Council Ref: OA2021/0009

Subject: Request for Comments - State Significant Development (SSD)
Application No: SSD-17899480
Property: 23-27 Lytton Street WENTWORTHVILLE NSW 2145,
Proposal: Redevelopment of Wentworthville Northside West Clinic, including demolition of a two-storey west wing building and southern car park, tree removal and construction and operation of a four-storey extension, alterations and additions to the Stage 1 building, landscaping and new car parking

Figure 9: Floorplan of Stage 2, Level 3 with outdoor courtyard highlighted in red and distance to nearest noise sensitive receiver.

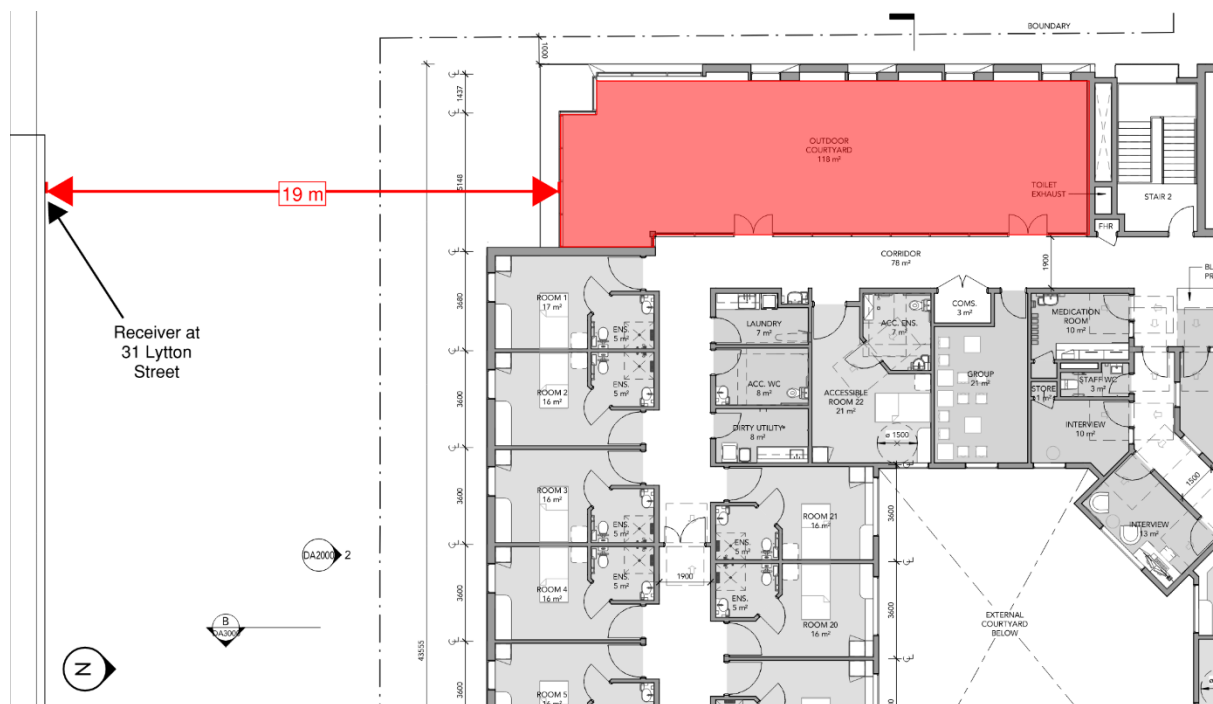
7. No details provided regarding assessment of noise that will be generated from the proposed upper levels outdoor courtyards.

Figure 4 Section B-B (Team 2 Architects 2021)

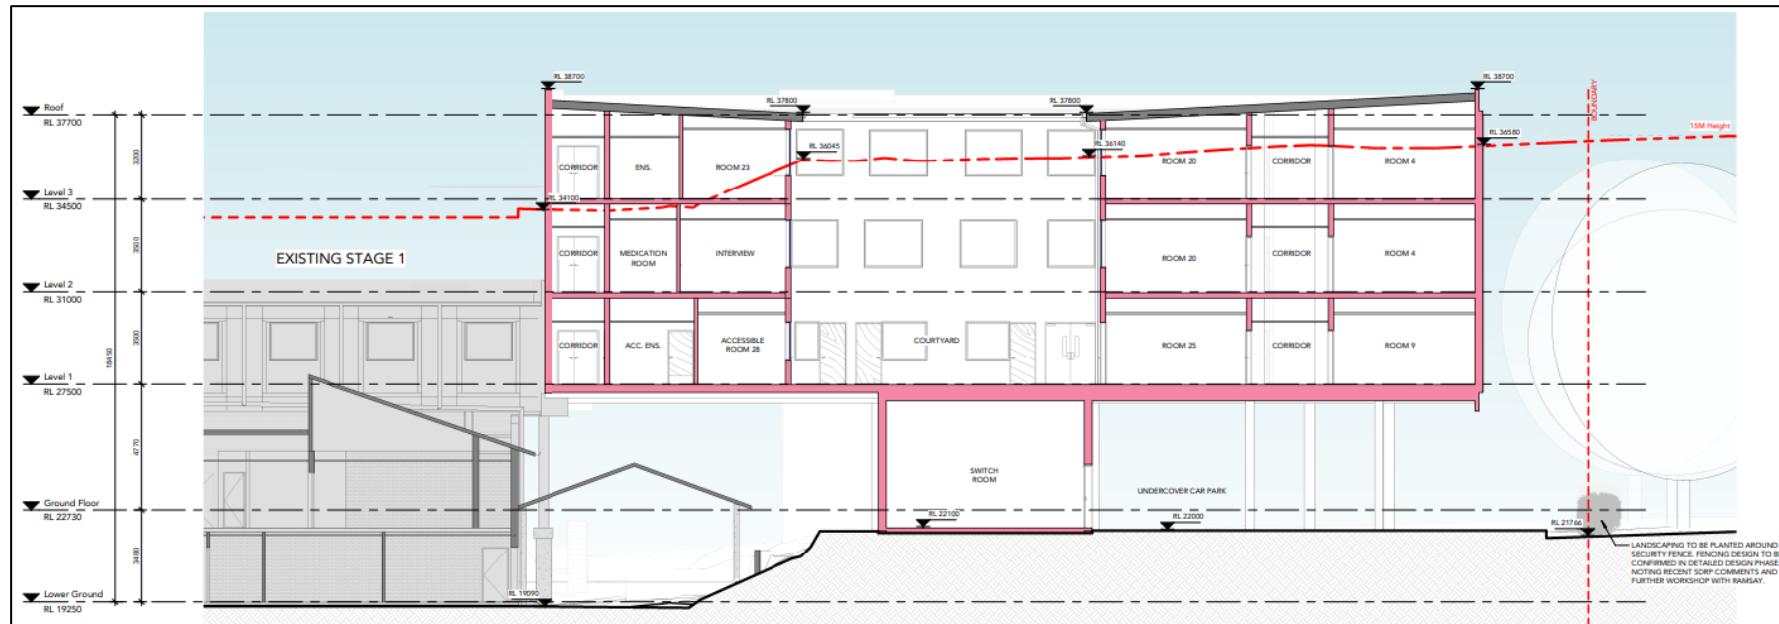
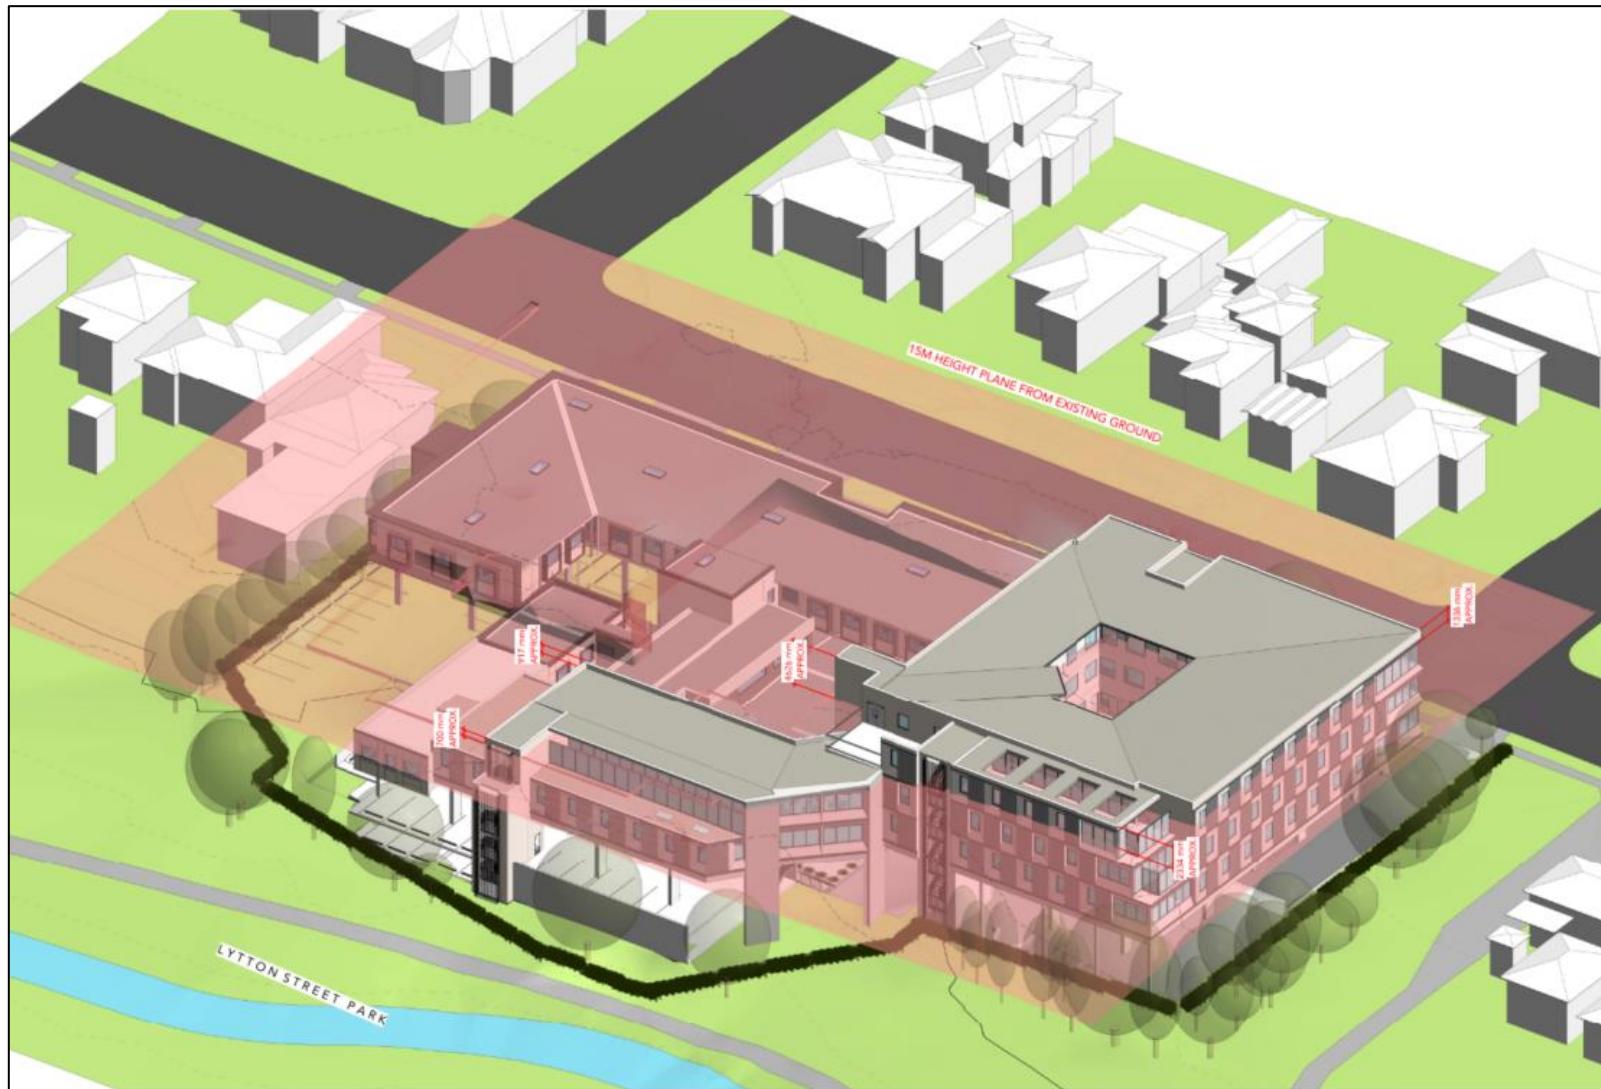
1. Council objects to the breach proposed for both of the building height and floor space ratio (FSR) controls. The proposed development is seeking to contravene the Cumberland Local Environmental Plan (CLEP) 2021 development standards for building height by 30.7% and FSR by 9.45%. The proposed exceedance in building height control includes habitable area that will increase overshadowing impact to Lytton Street Park towards the western and southern sides of the site. The variation proposed on the FSR control indicates bulk and scale that is inappropriate for the existing locality that is comprising of a higher residential density R4 zoning towards the northern part of the site and a lower residential density R2 zoning towards the eastern and southern sides of the site. The proposed contravention of the development standards will set undesirable precedence on the building height and FSR within the existing streetscape. The development fails to positively contribute to the character of the area and fails to replicate positive features of surrounding development. The proposed building is imposing, is greater in scale than the neighbouring development, and results in an inappropriate balance between the built and natural forms. For these reasons, clause 4.6 submitted with the application is not considered satisfactory, as the proposed development will not be in the public interest because it is inconsistent with the objectives of the particular standard and the objectives for development within the zone in which the development is proposed to be carried out.

- b) **Height** – The permitted number of storeys shall not exceed 4 for a 15m building height limit within the locality being a high density residential area. Part of the proposed building appears to contain a 5 storey element that is incompatible with the existing adjoining developments. This has not been demonstrated.
